**Albuquerque
Metropolitan
Arroyo
Flood
Control
Authority**

Re: Seville Estates Subdivision Grading & Drainage Plan, ZAP A-10
Engineer's Stamp Dated September 30, 2003

AMAFCA received the revised plan and offers the following comments:

SEVILLE ESTATES
GRADING AND DRAINAGE PLAN - A

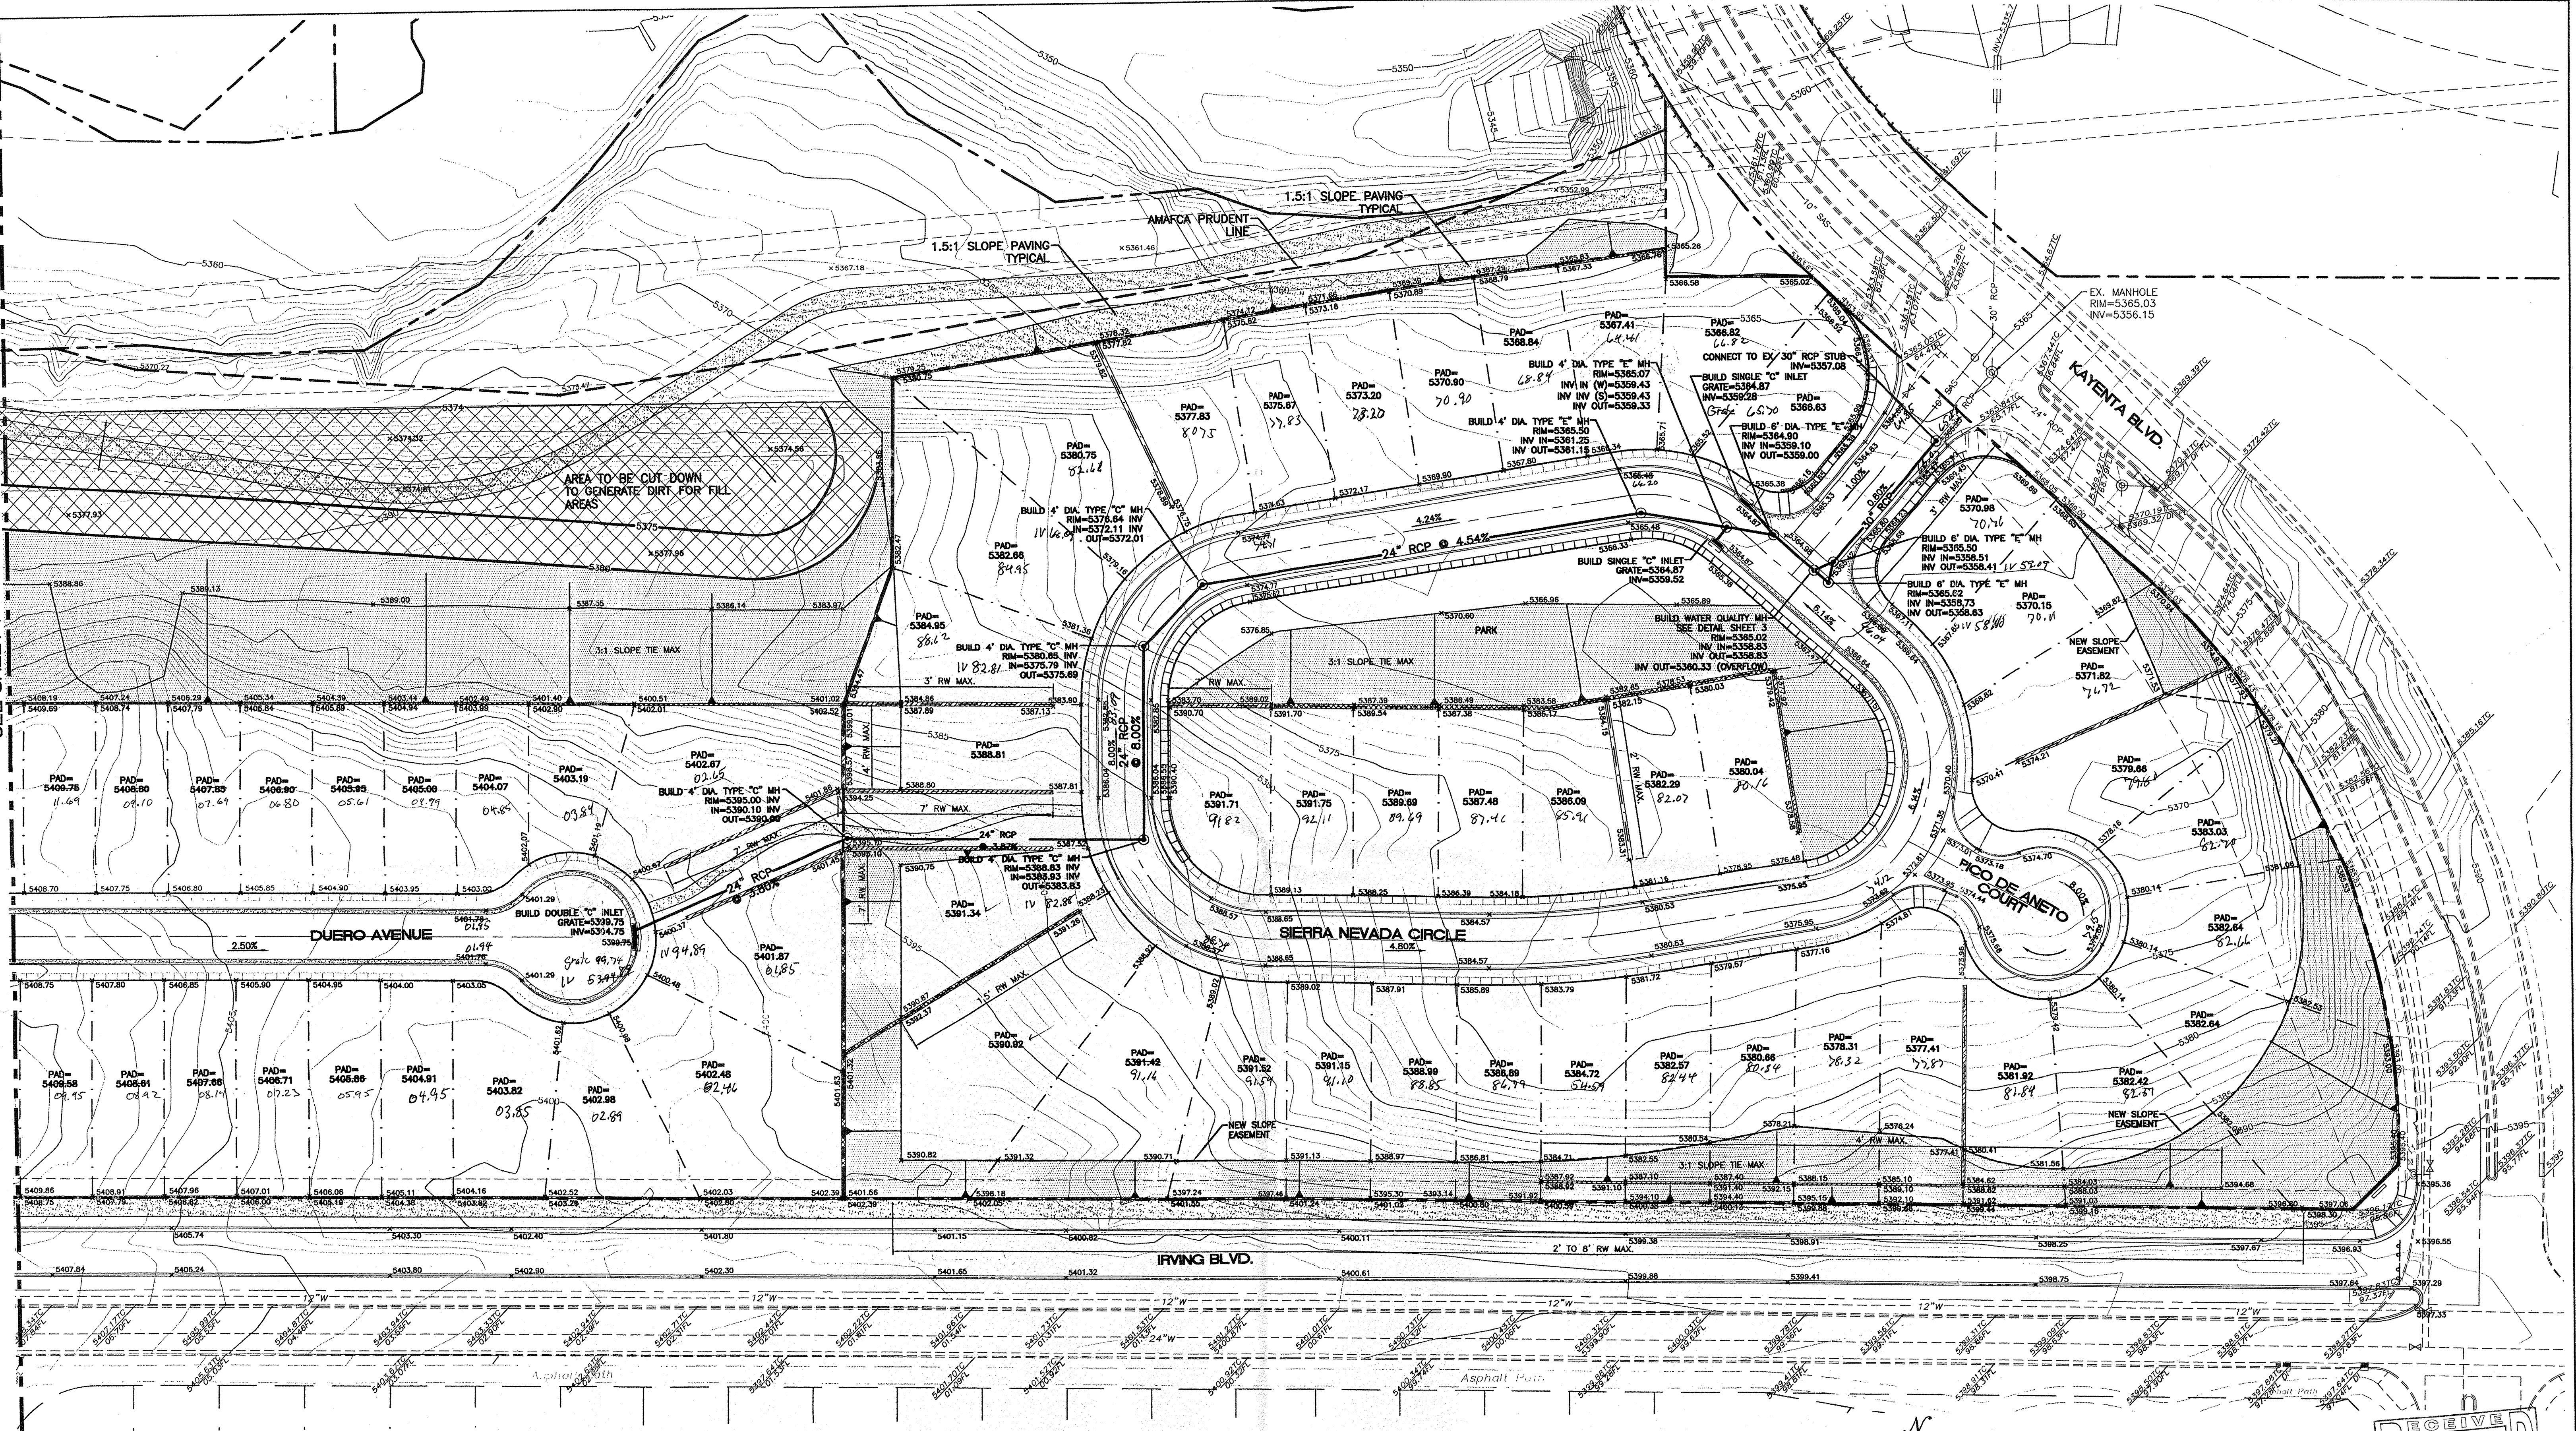
1. It is not necessary to have both a water quality manhole and inlet. In this case, the flows are small enough so that a water quality inlet will suffice.
2. Show the existing drop structure in the Calabacillas Arroyo.
3. AMAFCA recommends a more direct storm drain alignment to the arroyo (see attached) that will not require manholes.
